Your ref:
Our ref: 22/00455/F
Please ask for: Miss Sandra Homcenko
Direct dial: 01553 616824
E-mail: borough.planning@west-norfolk.gov.uk

Details: **Replacement of 9 single glazed Crittall windows on the 1950's extension on the south, east and north sides of the building. These will be replaced with aluminium framed narrow profile double glazed units. These will be in white as existing. at Nelson Memorial Hall Church Lane Burnham Thorpe King's Lynn Norfolk**

Nelson Memorial Hall, Burnham Thorpe, Norfolk, PE31 8HT

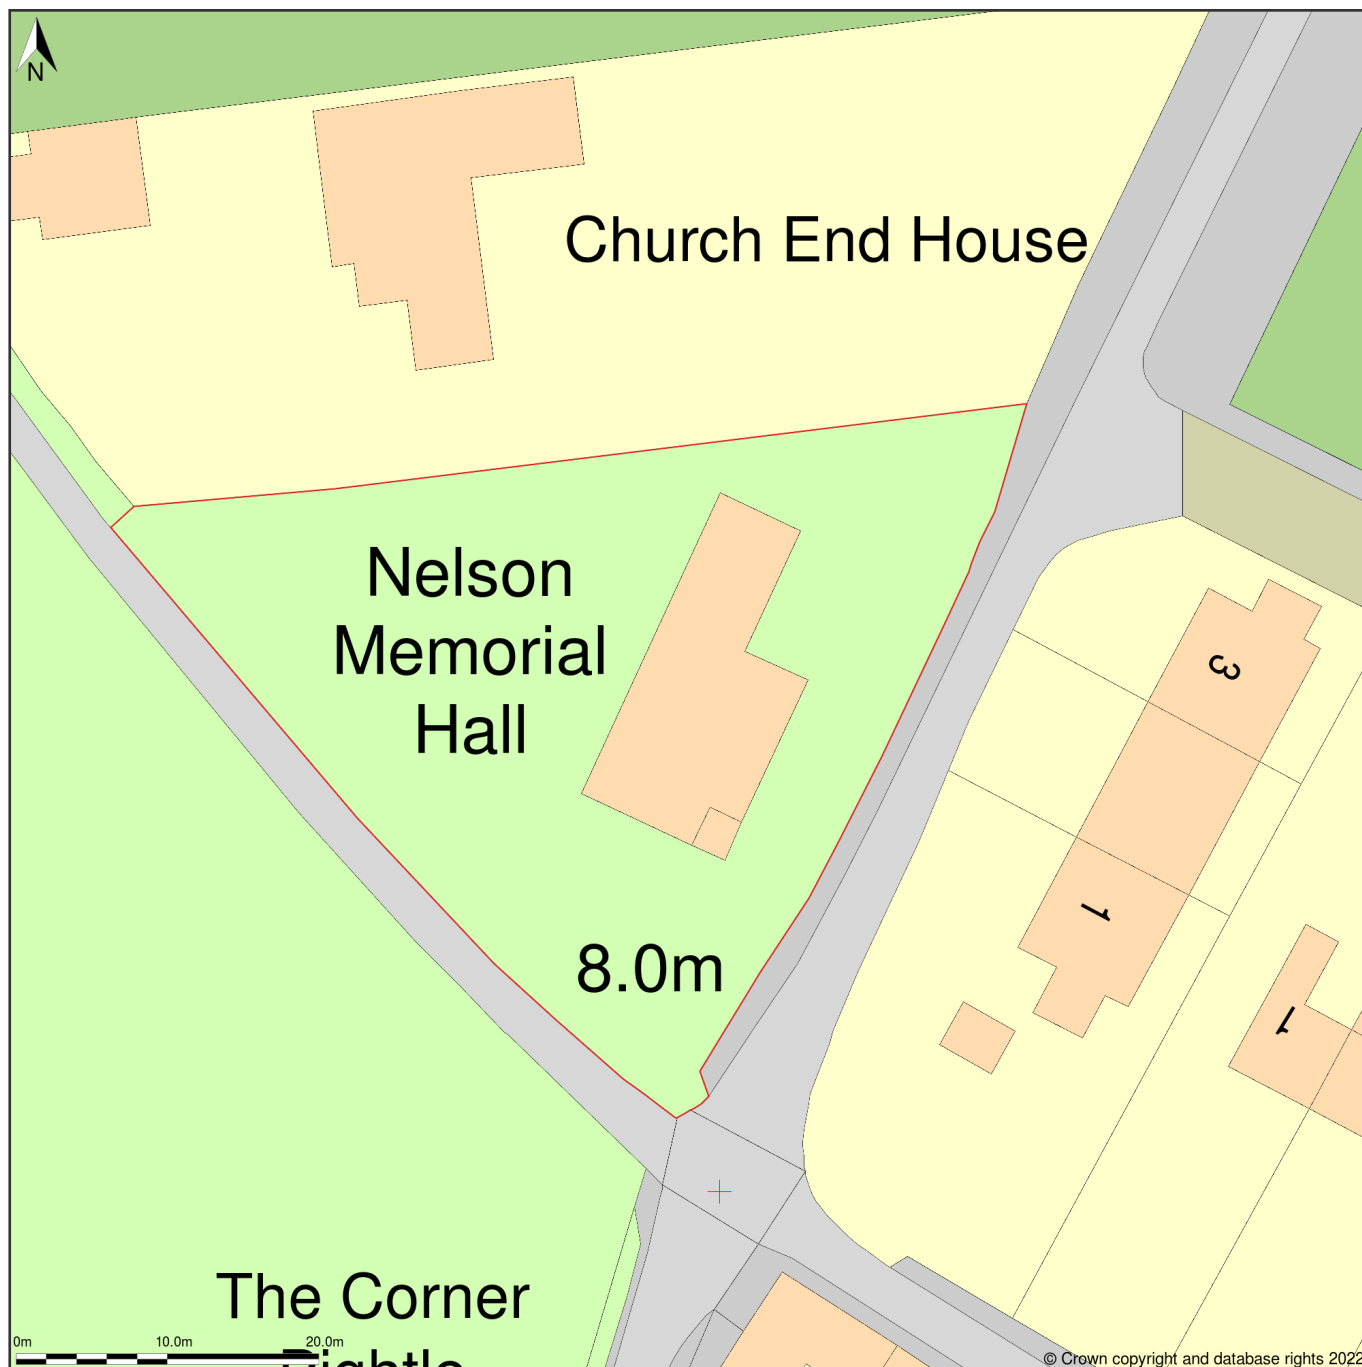
1. Apologies however it appears that Location and Block plans are out of scale, when using your measurement to draw on our system the polygon looks very different to the plan you have provided, in places it does not reach some of the boundaries. Please revise and forward amended plans.
It may be useful to use more up to date plans on www.planningportal.co.uk or www.buyaplan.co.uk
